Planning Application Reference No.: 3/2026/0315

Address of Development: Chatburn Road, Clitheroe (Oakmere Homes)

Comments: Ref application ref 3/2026/0315 by Oakmere Homes.

DRAINAGE LAYOUT
SHEET 2

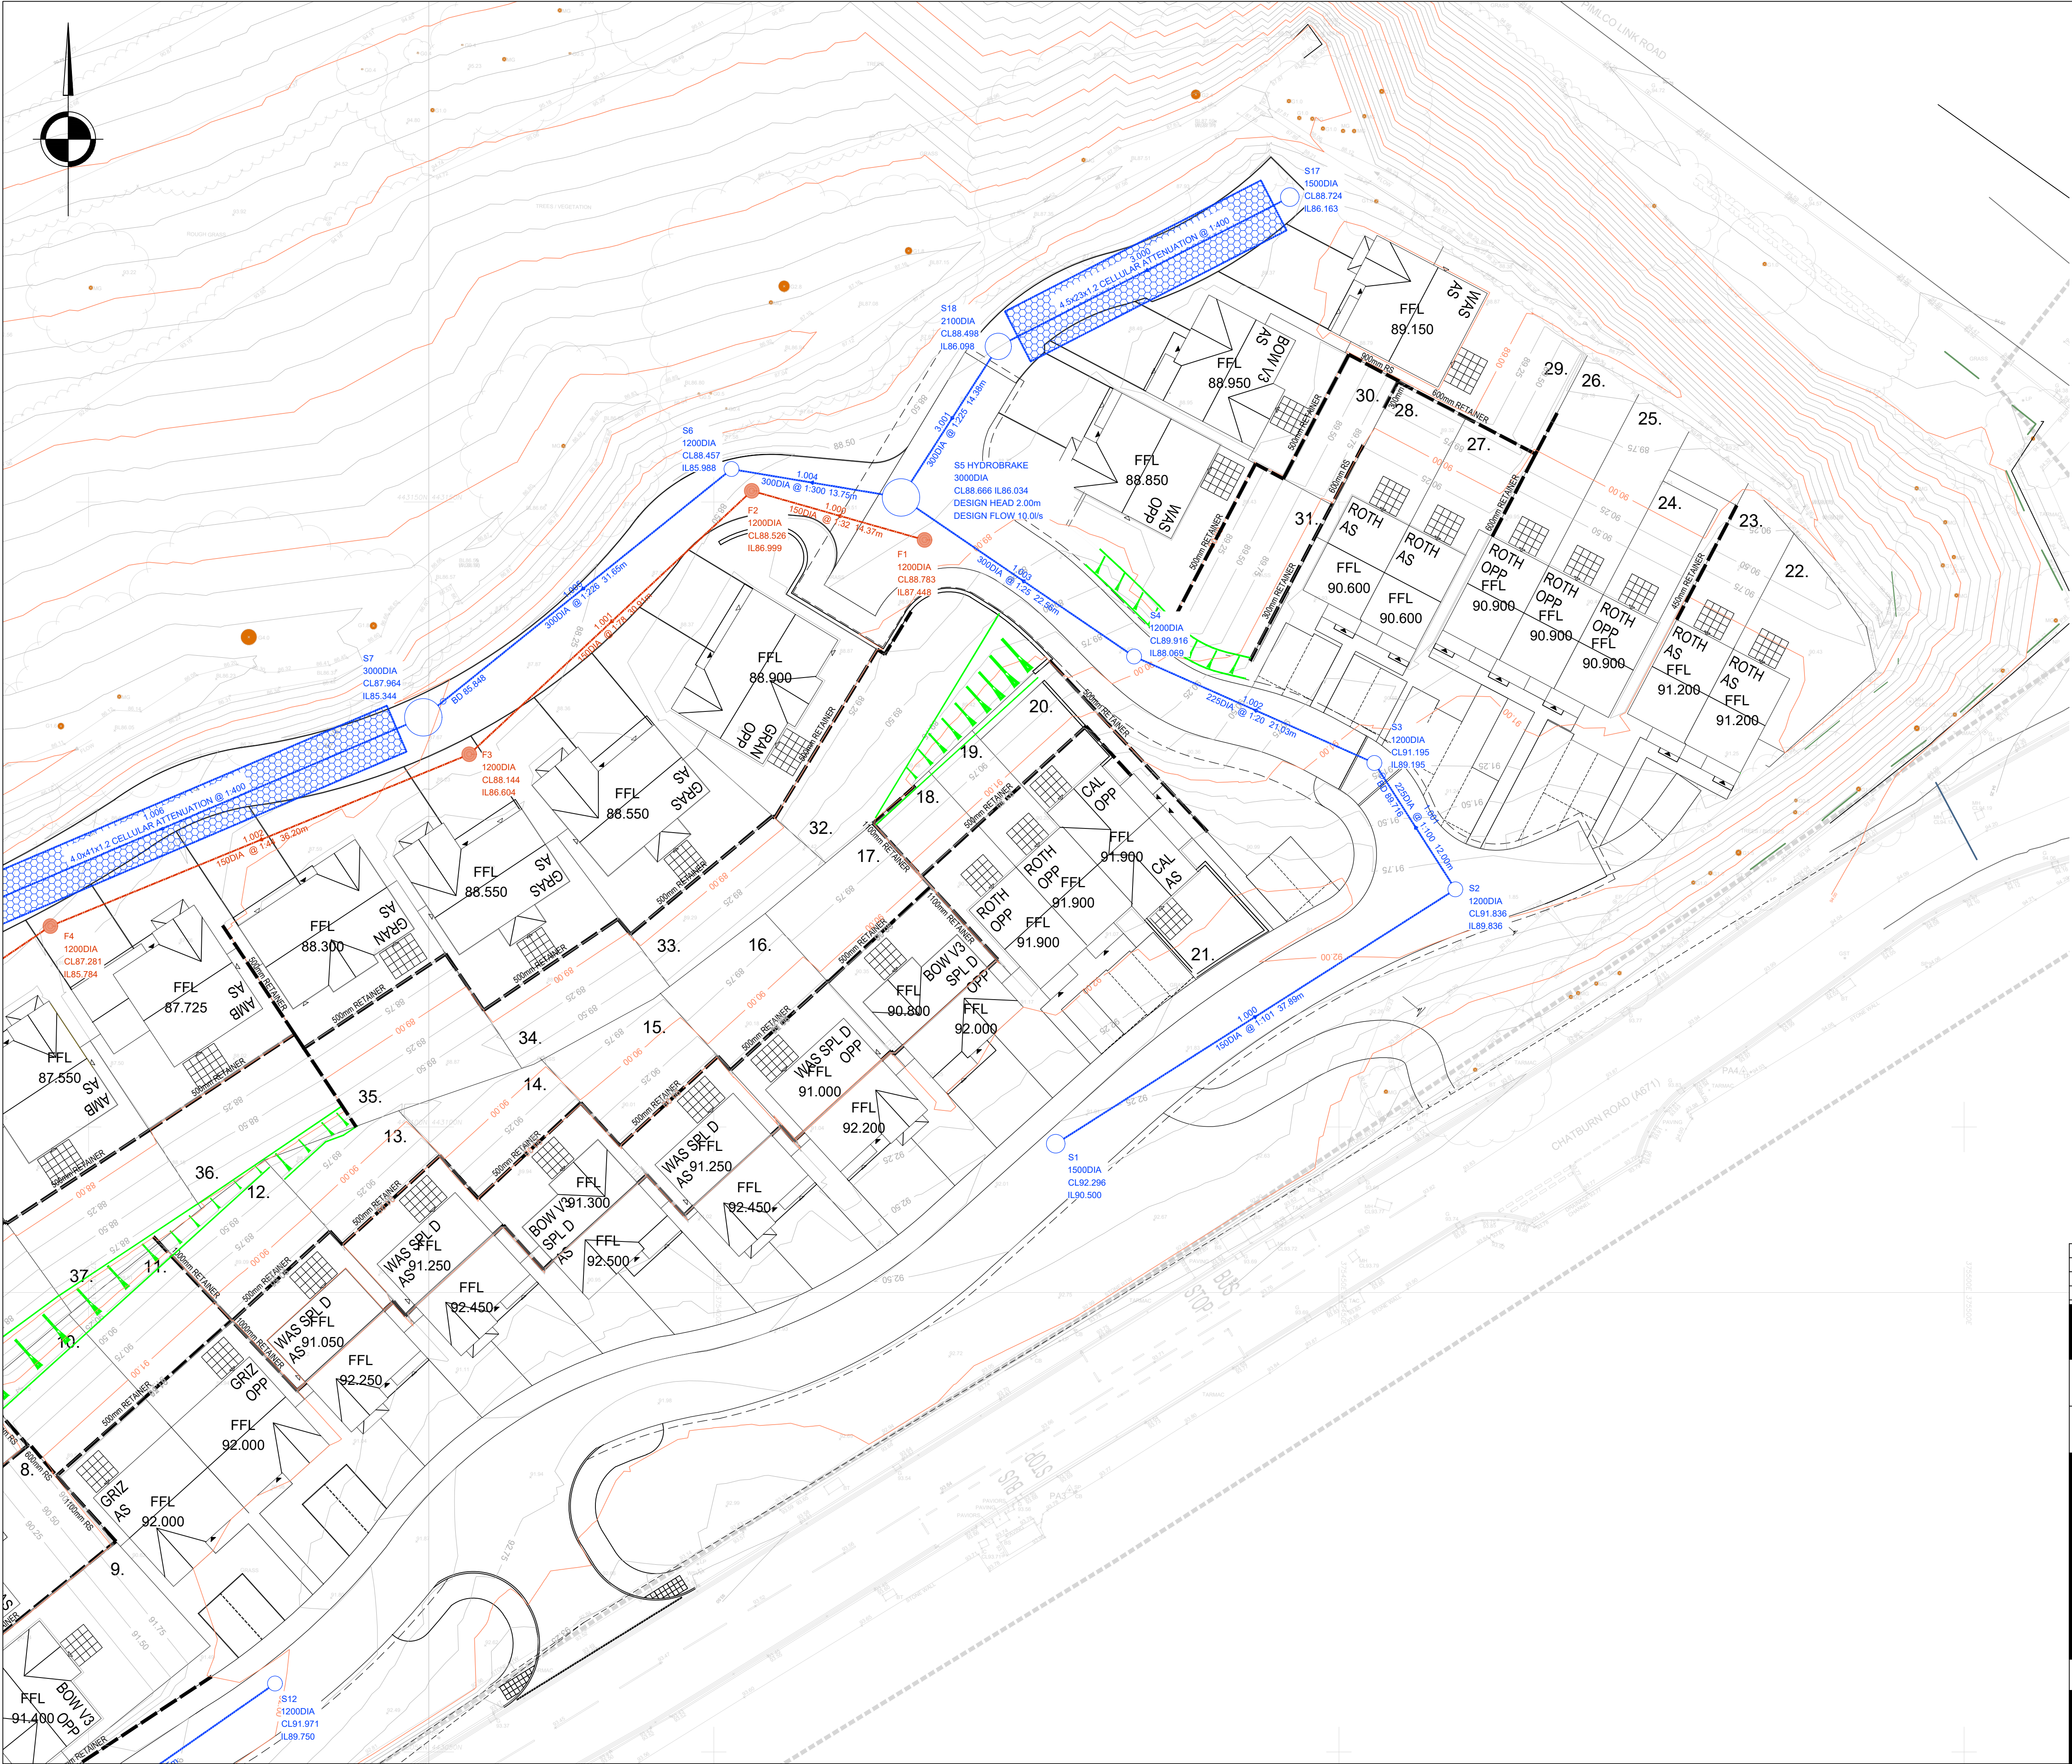
My concern re the plans for phase 3, if I have understood them correctly, is that a further pump will be added for this phase that will push waste up the riser in Bellman Way to empty to the sewer in Chatburn Rd. If the pump servicing phases 1 and 2 has unresolved issues then adding phase 3 waste to the riser will exacerbate these.

You should therefore ensure that planning conditions are set to ensure Oakmere agrees a solution, either by remedying the pump issue with phase 1 and 2 so that its power and reliability is such that adding phase 3 waste upstream in the riser has no impact. Or, that any waste drainage for phase 3 is totally independent to that of phase 1 and 2. The current planning application by Oakmere Homes, if approved, provides an opportunity for the developer and the RV planning department via planning conditions to correct this issue at no cost to phase 1 and 2 residents.
